## Addendum Response to Agency Submissions (SSD 7275), 80-88 Regent St, Redfern

The following table includes a response to the full text of submissions provided by or on behalf of State and local government agencies. For completeness, the full text of each submission is provided in the left-hand column, accompanied by the proponent's corresponding response in the right-hand column. The proponent's responses have been informed by input by the expert consultant team and should be read in conjunction with the attachments as well as the exhibited Environmental Impact Statement and the Response to Submissions documentation submitted on the 24 January 2019.

**Figure 1: Ground floor plan comparison**

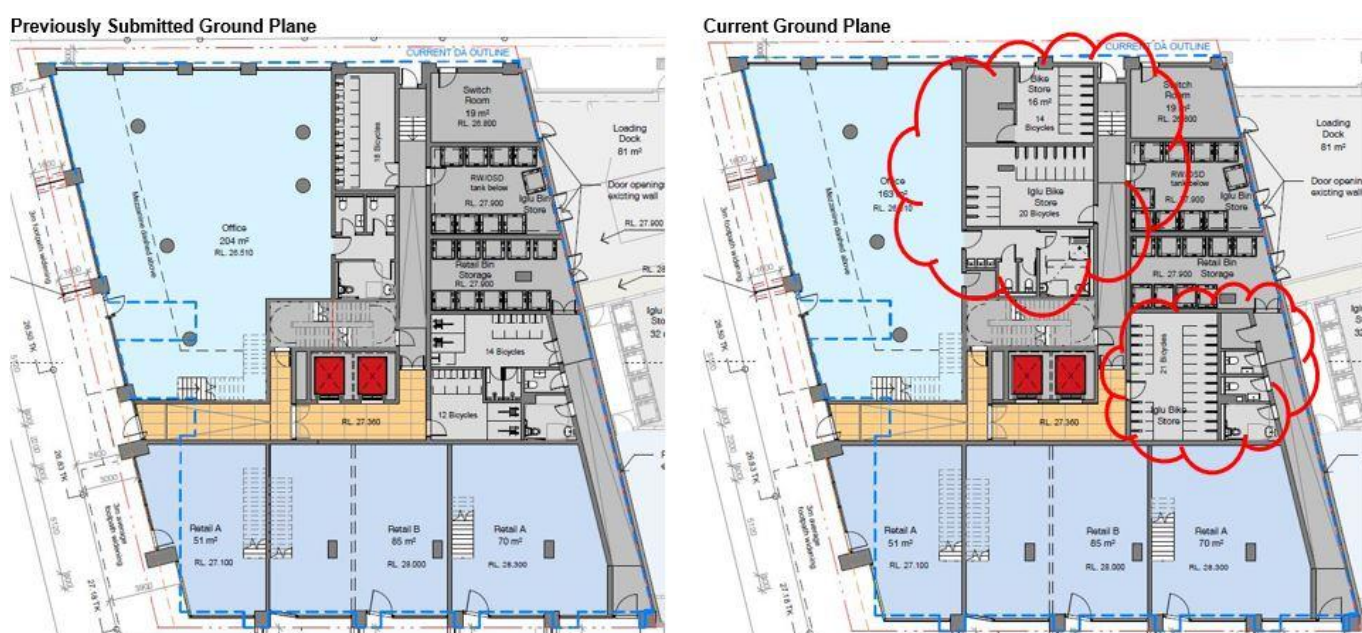
GA 2a	There were a number of other items that you raised during the last design review meeting, in particular with regard to the City of Sydney's submission, and we trust that these items have been addressed by the applicant also.	Noted.
GA 3a	One very minor item is the presence of stairs between the Bike Storage for 18 bicycles and the William Street exit. In design terms it would be preferable to consolidate student bicycle storage and end of trip facilities so that access to the street is direct and doesn't require level entry changes.	The bike storage arrangement at the ground level has been modified as illustrated on the Architectural Drawings at <b>Attachment A</b> and discussed further at <b>Section 1.1</b> of the Cover Letter. The bike storage areas have not been consolidated as they are allocated to different uses. Two ground floor bike storage areas containing a combined total of 41 bike parking spaces have been dedicated to the student accommodation use and one storage area to the retail/commercial tenants containing 14 bike parking spaces. All ground floor bike storage areas can be accessed via the Marian Lane entrance, however the in response to the GANSW's recommendation, the retail/commercial bike storage area has direct access to William Lane.

DWG. TITLE
Landscape Plan - Roof Terrace

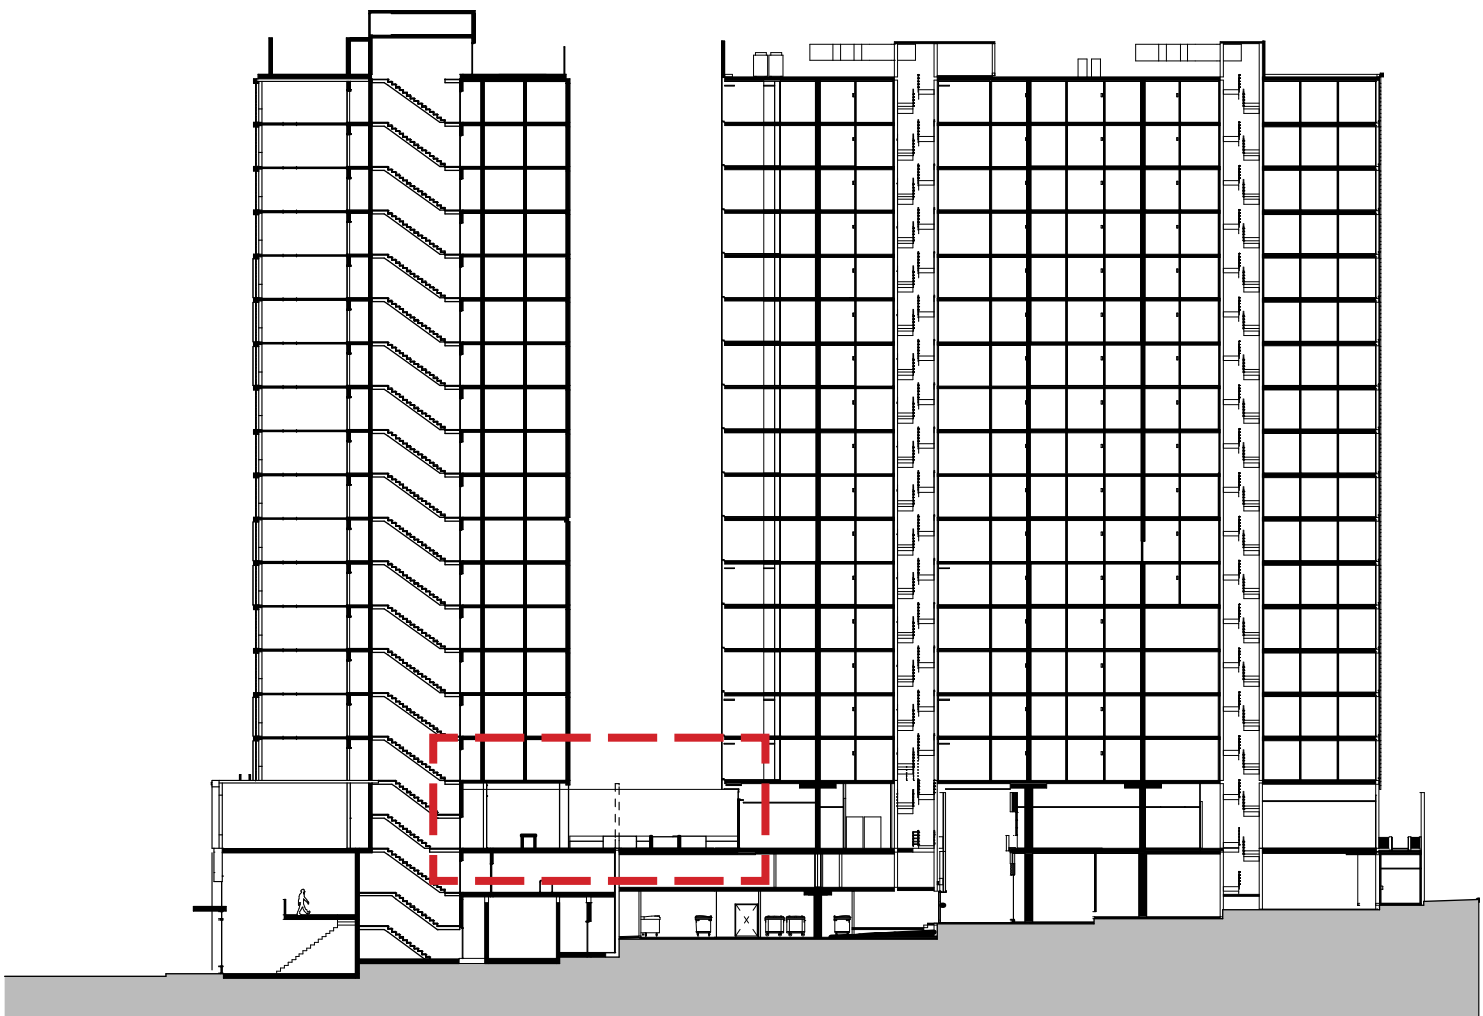
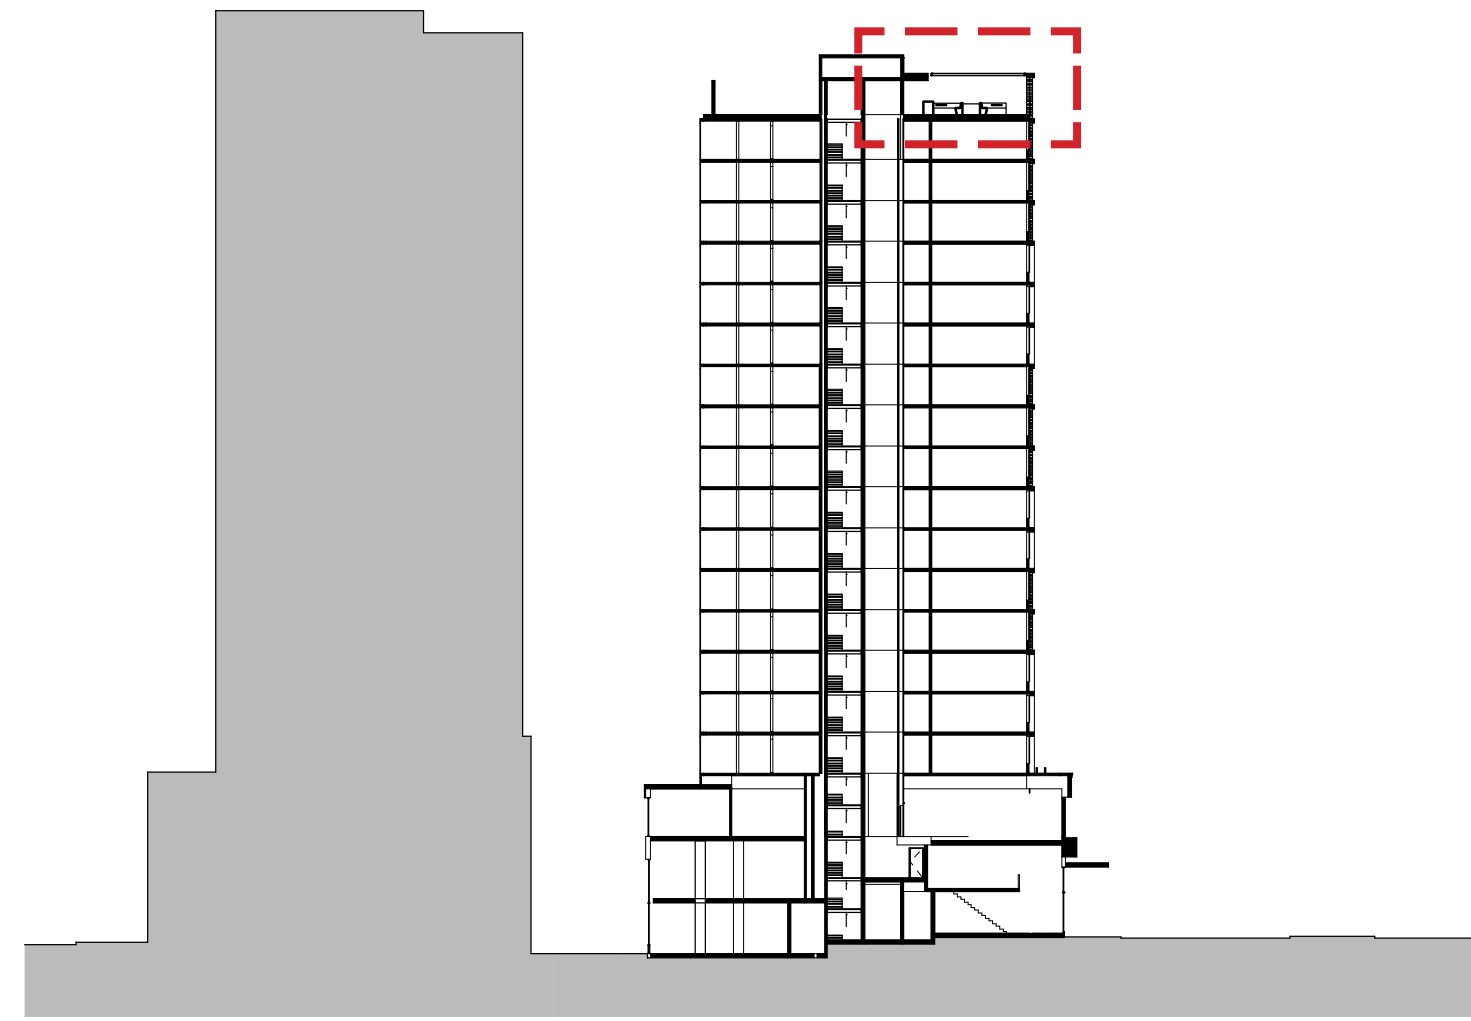
Item Raised		Proponent's Response
		North Western Face of the courtyard of <i>Bambusa Textillis Gracillis</i> which grows to 6m in height which will provide supplementary wind mitigation to the satisfaction of Windtech's recommendations.
CoS 9a	<b>Level 17 rooftop terrace</b> <ul style="list-style-type: none"> <li>This is a new development and there should be no reason why structural loads are not designed to achieve minimum soil depth for trees on slab.</li> </ul>	Refer to the Landscape Cover Letter and Amended Landscape Plans at <b>Attachment F</b> . An additional section has been prepared to illustrate the fold in the Level 1 courtyard slab to support growing media for the proposed <i>Chamerops humillis</i> .
CoS 9b	<ul style="list-style-type: none"> <li>It is also noted that the landscape section and annotations show a planter depth of 850mm, not 900mm.</li> </ul>	Refer to the Landscape Cover Letter and Amended Landscape Plans at <b>Attachment F</b> . All podium gardens have been increased to achieve a minimum planter depth of 900mm with localised mounding around trees up to 1200mm in depth.

CoS 9c	<ul style="list-style-type: none"> <li>No additional plans or details have been submitted for the arbour and roof top design. As this is a detailed (and final) development application, these matters should be properly address prior to determination of the application.</li> </ul>	A detailed roof plan has been prepared and is provided at <b>Attachment A</b> .
CoS 9d	<ul style="list-style-type: none"> <li><i>Ulmus parvifolia</i> 'todd' are deciduous trees that shed leaves. The design is reliant on trees to reduce high wind impacts. During winter, as well as period in autumn and spring, the Level 1 common open space will be a windy and uncomfortable space.</li> <li>It is also noted that the <i>Chamerops humillis</i> is a dwarf Mediterranean palm.</li> <li>The palm planter detail within a deep fold in the structural slab is not included in the plans. Details have not been provided to demonstrate the planter feasibility</li> </ul>	Refer to the Landscape Cover Letter and Amended Landscape Plans at <b>Attachment F</b> . There has been a change of tree species within the Level 1 courtyard. The courtyard landscape plan now includes <i>Cupaniopsis anacrdioides</i> (Tuckeroo) to provide a dense evergreen, interlocking canopy to mitigate against wind. It should also be noted the Level 1 podium landscape design also incorporates a planter along the North Western Face of the courtyard of <i>Bambusa Textillis Gracillis</i> which grows to 6m in height which will provide supplementary wind mitigation to the satisfaction of Windtech's recommendations.

CoS 9e	<ul style="list-style-type: none"> <li>The planter depths do not comply with the minimum soil depths in the Sydney Landscape Code. As noted earlier, this is a new building that should be designed to accommodate the structural loads required.</li> </ul>	Refer to the Landscape Cover Letter and Amended Landscape Plans at <b>Attachment F</b> . An additional section has been prepared to illustrate the fold in the level 1 courtyard slab to support growing media for the proposed <i>Chamerops humillis</i> . All podium gardens have been increased to achieve a minimum planter depth of 900mm with localised mounding around trees up to 1200mm deep.
CoS 10a	<b>Quality of communal open space and wind issues</b> <ul style="list-style-type: none"> <li>The landscape plans and architect plan layouts for Level 1 do not match Windtech's recommendation.</li> </ul>	Refer to the Landscape Cover Letter and Amended Landscape Plans at <b>Attachment F</b> . There has been a change of tree species within the Level 1 courtyard. The courtyard landscape plan now includes <i>Cupaniopsis anacrdioides</i> (Tuckeroo) to provide a dense evergreen, interlocking canopy to mitigate against wind. It should also be noted the Level 1 podium landscape design also incorporates a planter along the North Western Face of the courtyard of <i>Bambusa Textillis Gracillis</i> which grows to 6m in height which will provide supplementary wind mitigation to the satisfaction of Windtech's recommendations.
